**DELEGATED DECISION FOR APPLICATION FOR CERTIFICATE OF
LAWFUL DEVELOPMENT**

Reference no.: 2026/CL/90747/W

Site: 342, Bradley Road, Bradley, Huddersfield, HD2
1PU

Description: Certificate of lawfulness for proposed erection of
single storey rear extensions and associated alterations

Drawing 2

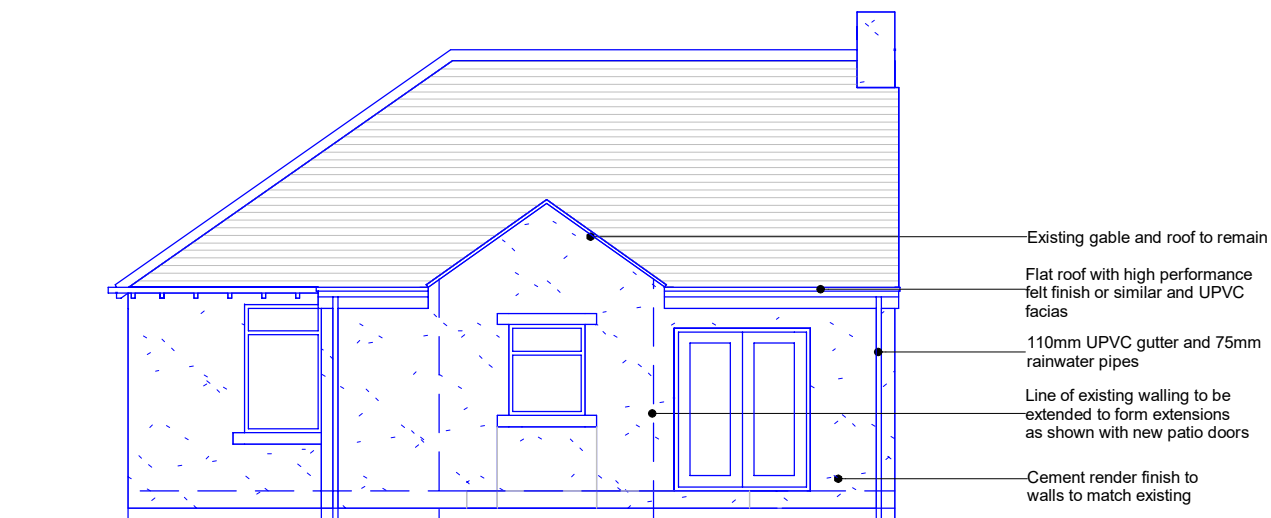
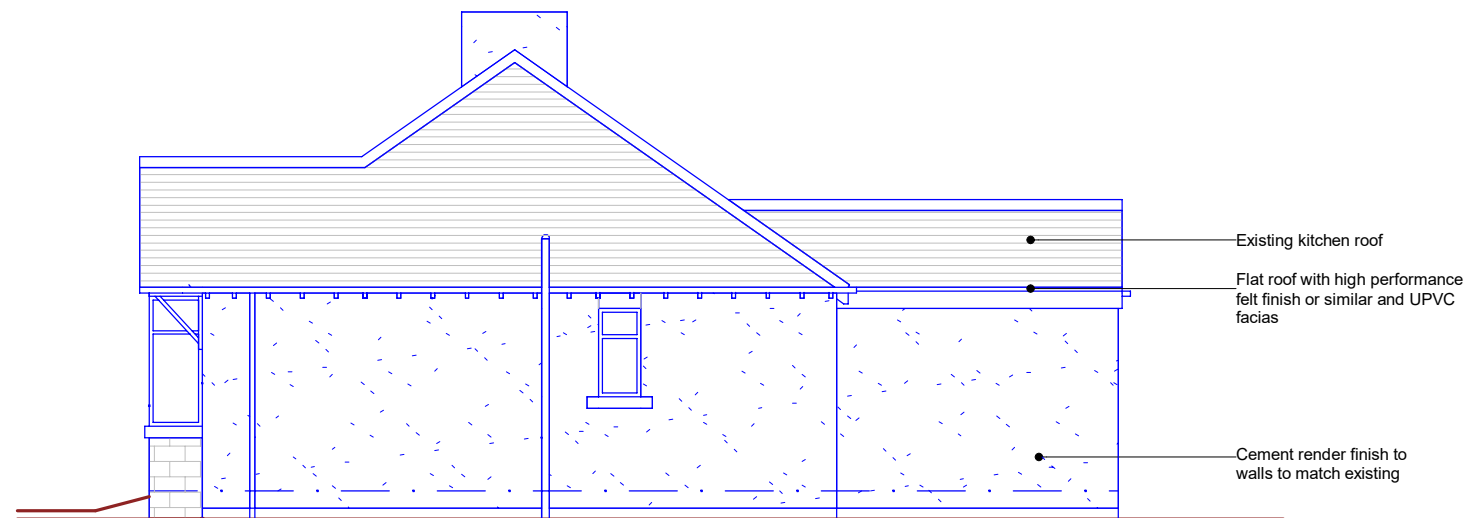
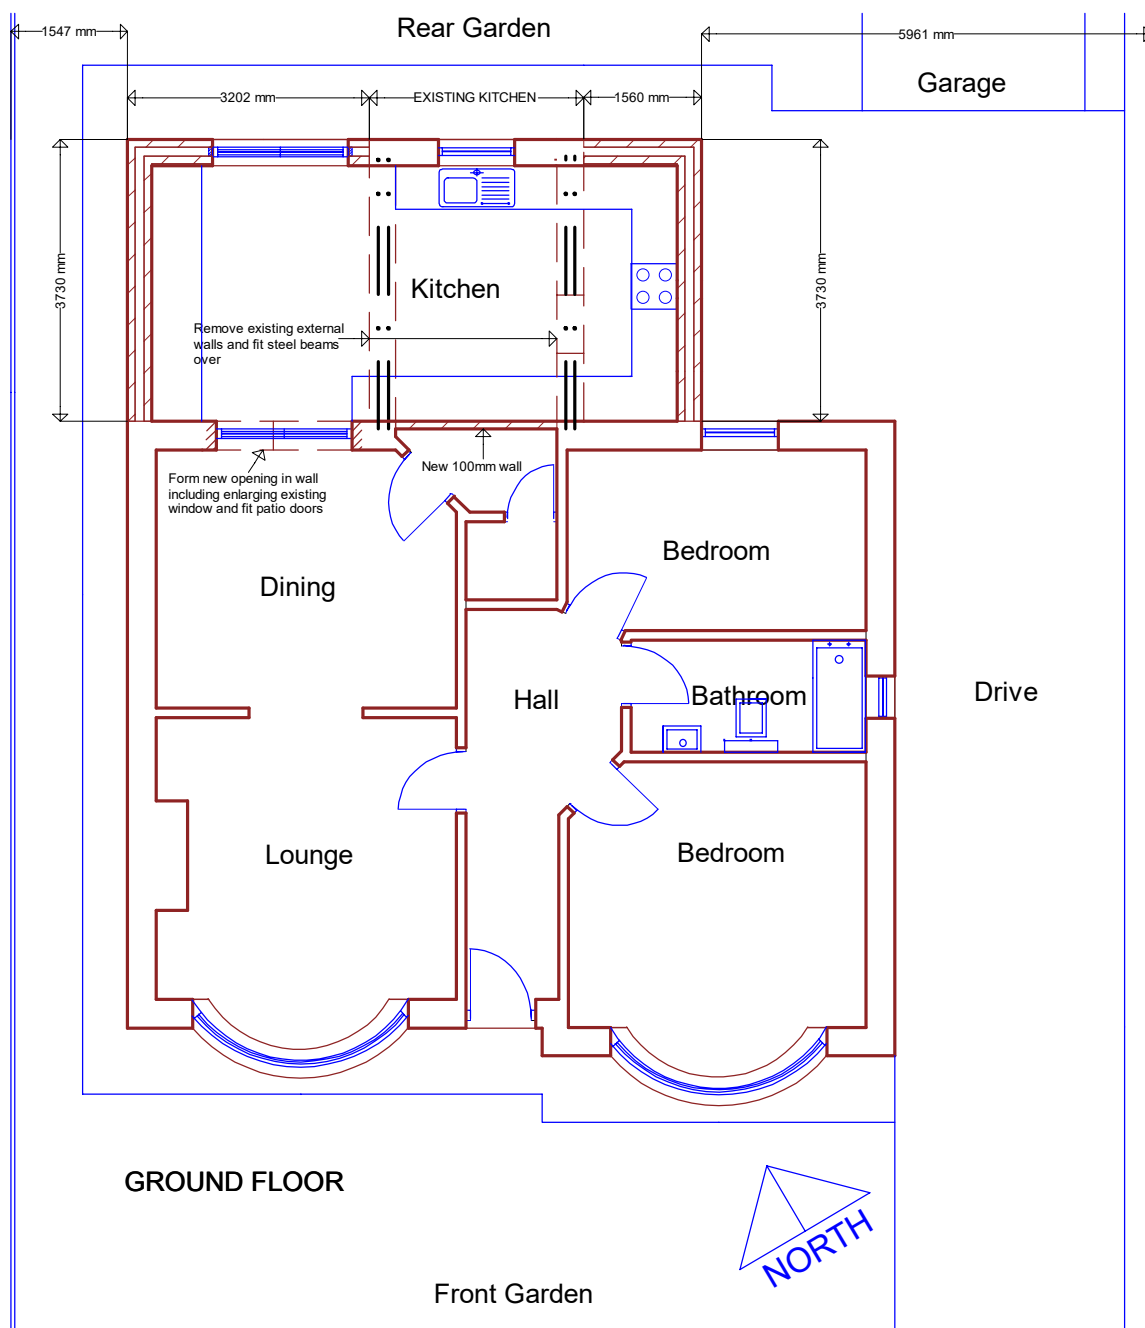
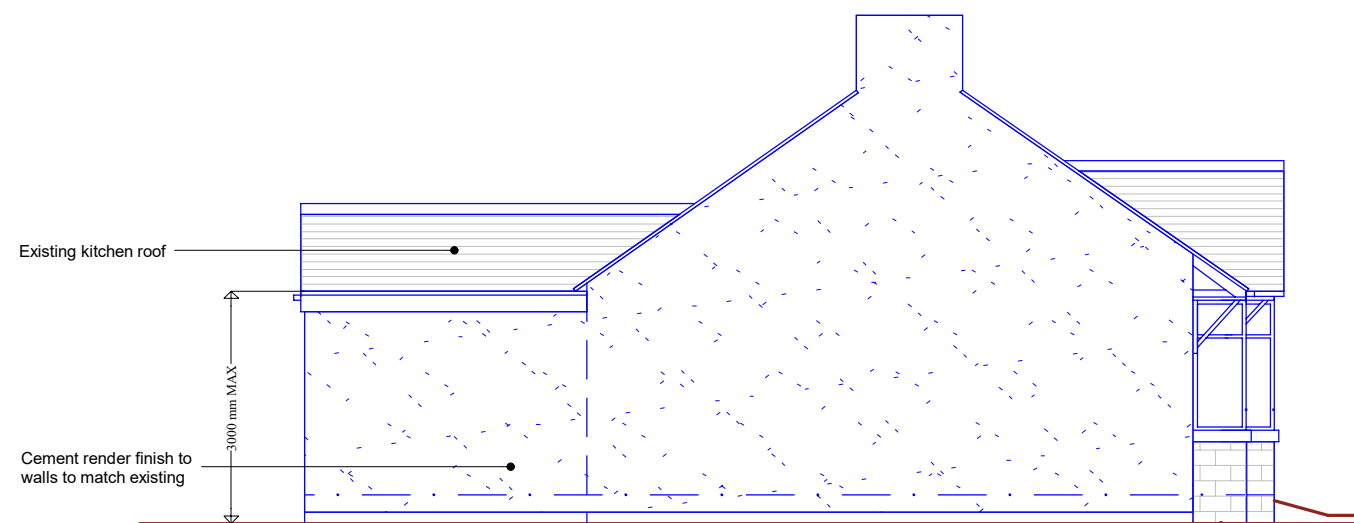
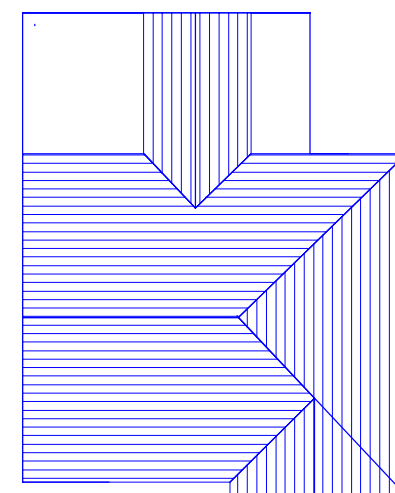
The proposed extensions would sit on either side of the outrigger. As the outrigger is an original structure, the enlargements would project off the side elevations of the original property and shall therefore be assessed as side and rear extensions.

The enlargement on the western side elevation of the outrigger would lie flush with the existing side elevation of the property and would project 3.7 metres to lie flush with the outrigger with a width of 3.2 metres. This part of the enlargement to the dwelling would have a flat roof with an overall height of 3 metres.

The enlargement on the eastern side elevation of the outrigger would be set in from the side elevation of the property by 2.6 metres and would also project 3.7 metres with a width of 1.6 metres. Again, the enlargement would have a flat roof with an overall height of 3 metres.

Comment: *The outrigger in which the extensions would project from is an original structure. Therefore, as demonstrated on page 22 of the Permitted development rights for householder – Technical Guidance document, the enlargements would also be deemed side extensions. The enlargements would not exceed 4 metres in height, would not have more than a single storey, however, when measure cumulatively, the structure would be more than half the width of the original dwellinghouse. The Technical Guidance is clear on page 23 that ‘if the proposed extension creates a total enlargement which has a width greater than half the width of the original dwellinghouse, it would not be permitted development.’*

The single storey rear extension does not benefit from a general planning permission planning permission under Article 3(1) and Schedule 2, Part 1, Class A of the Town and Country Planning (General Permitted Development) (England) Order 2015 (as amended) as the proposed enlargements would extend beyond a wall(s) forming the side elevation(s) of the original dwellinghouse and would have a width more than half the width of the original dwellinghouse contrary to sub-paragraph A.1 (j) (iii) of Class A.
